Our Ref: AB/132/19/HH
Your Ref:

Town & Country Planning Act 1990 (as amended)
Town & Country Planning (Development Management Procedure) (England) Order 2015
Application for Planning Permission for Works or Extension to a Dwelling

Development Erection of small detached outbuilding within the private rear garden of the property.
Location Kemp Barn Queens Lane Arundel

Dwg. no. KB/P/03

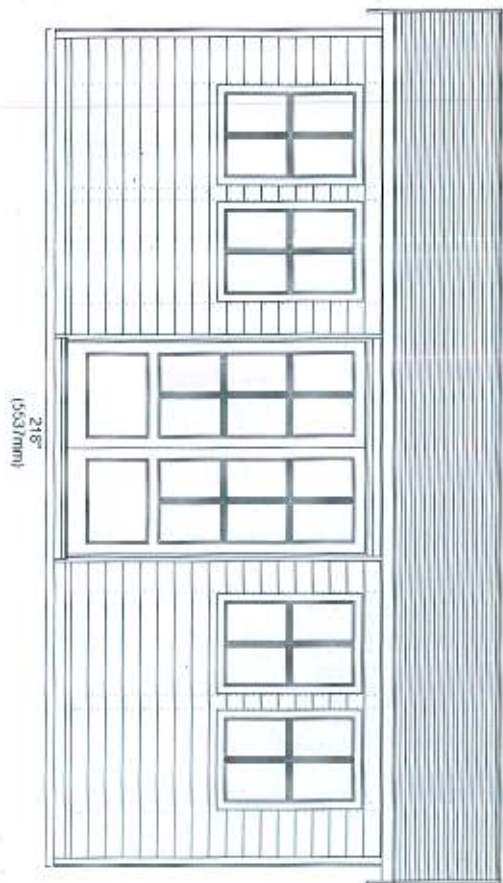
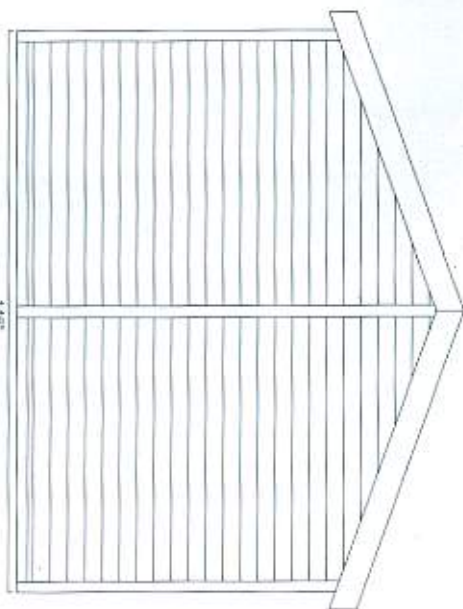
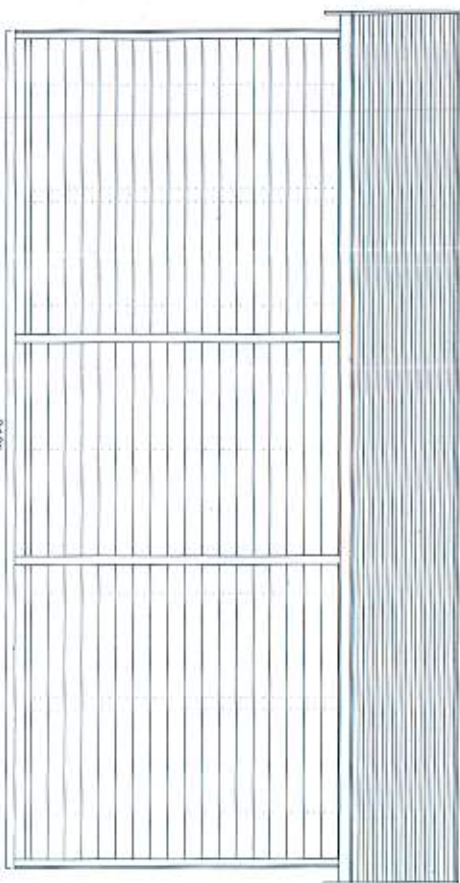
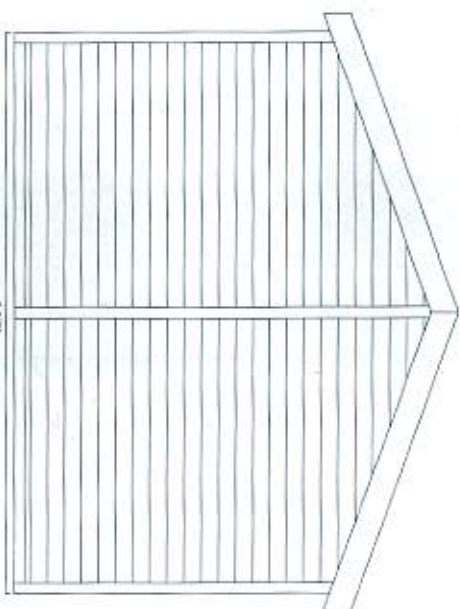
The floor and elevations do not accord. The door on the floor plan measures 1.35m and on the elevation measures 1.5m. Please amend accordingly and resubmit.

Please clearly label the floor and elevations plans as Proposed and resubmit.

BLOCK PLAN - 1:500

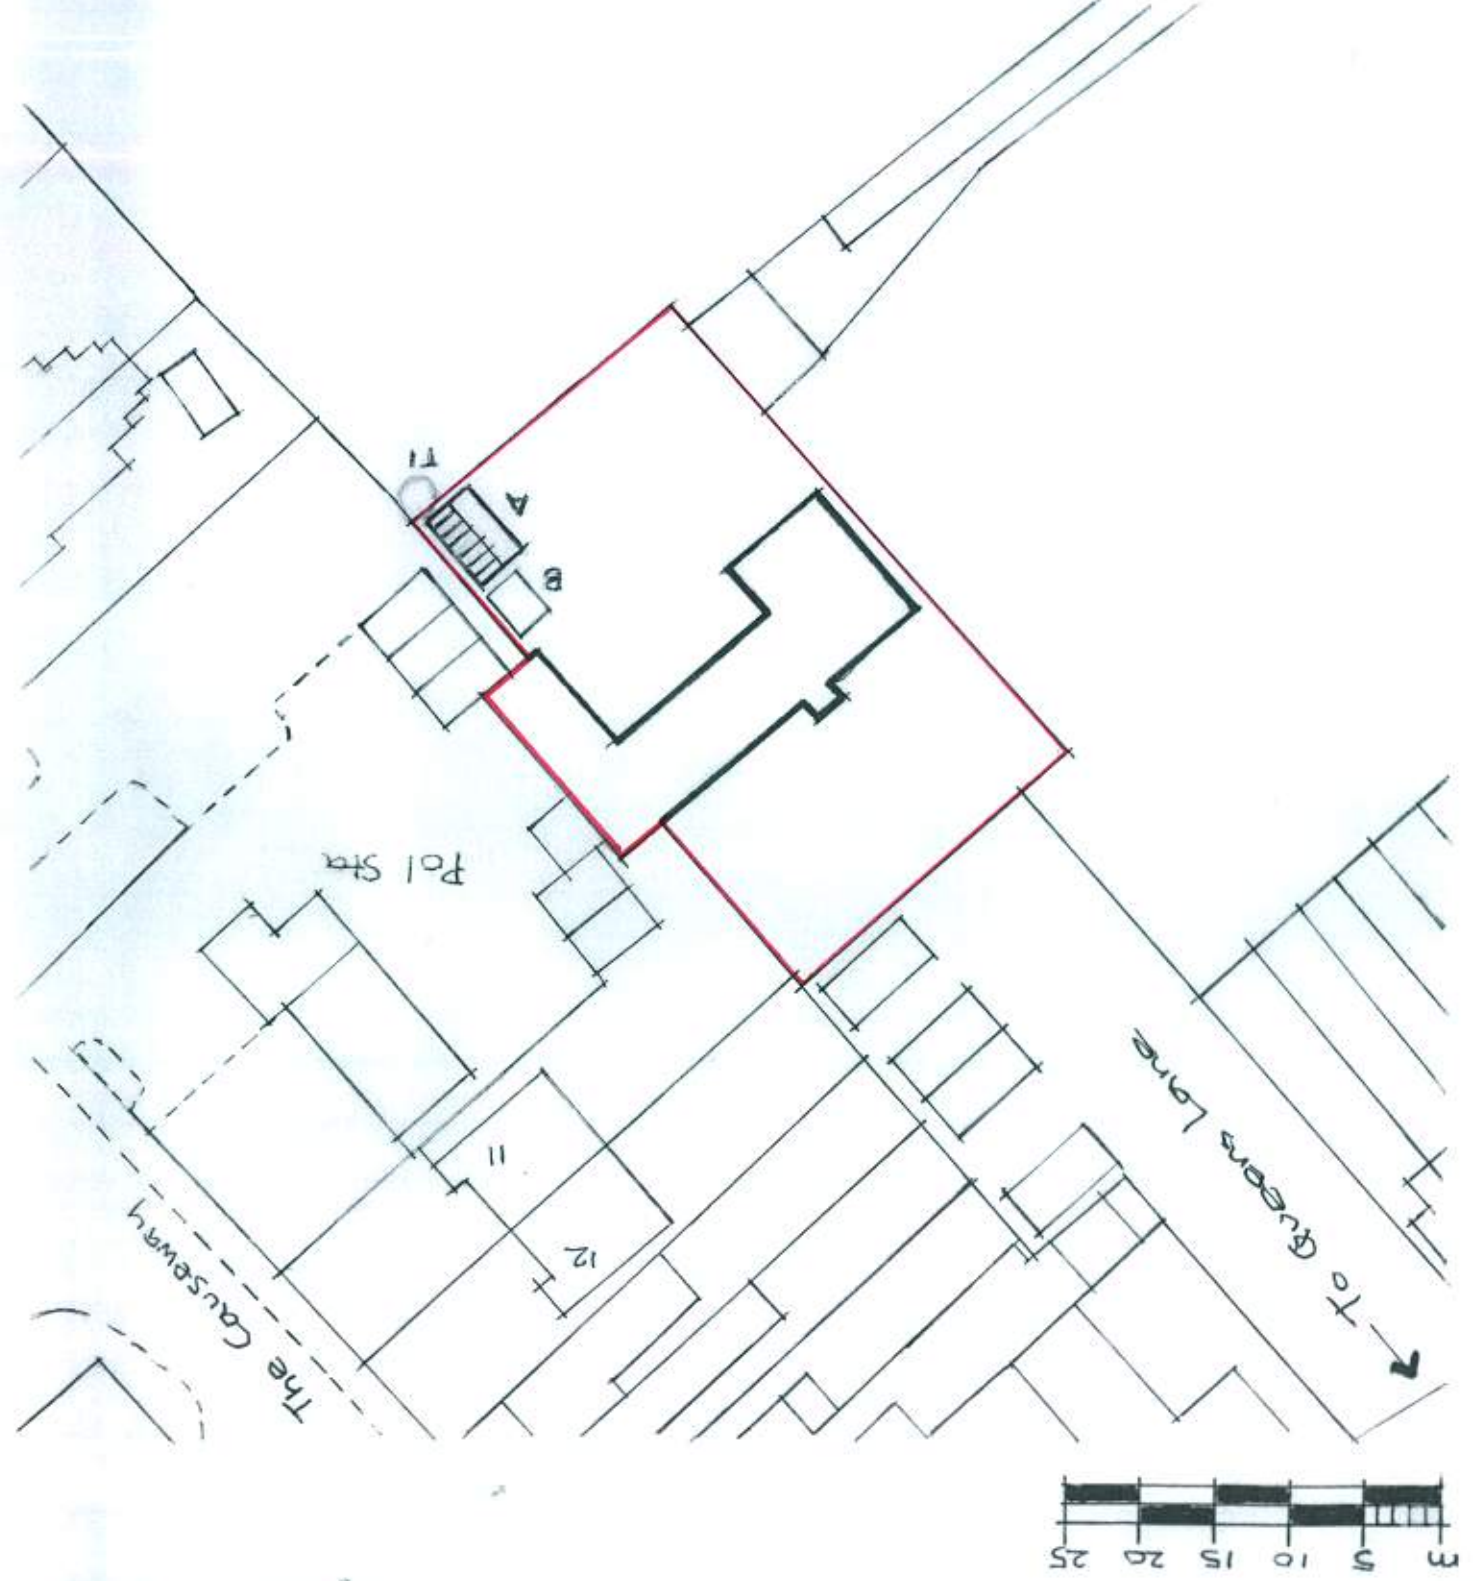
Please amend to show written dimensions to boundaries.
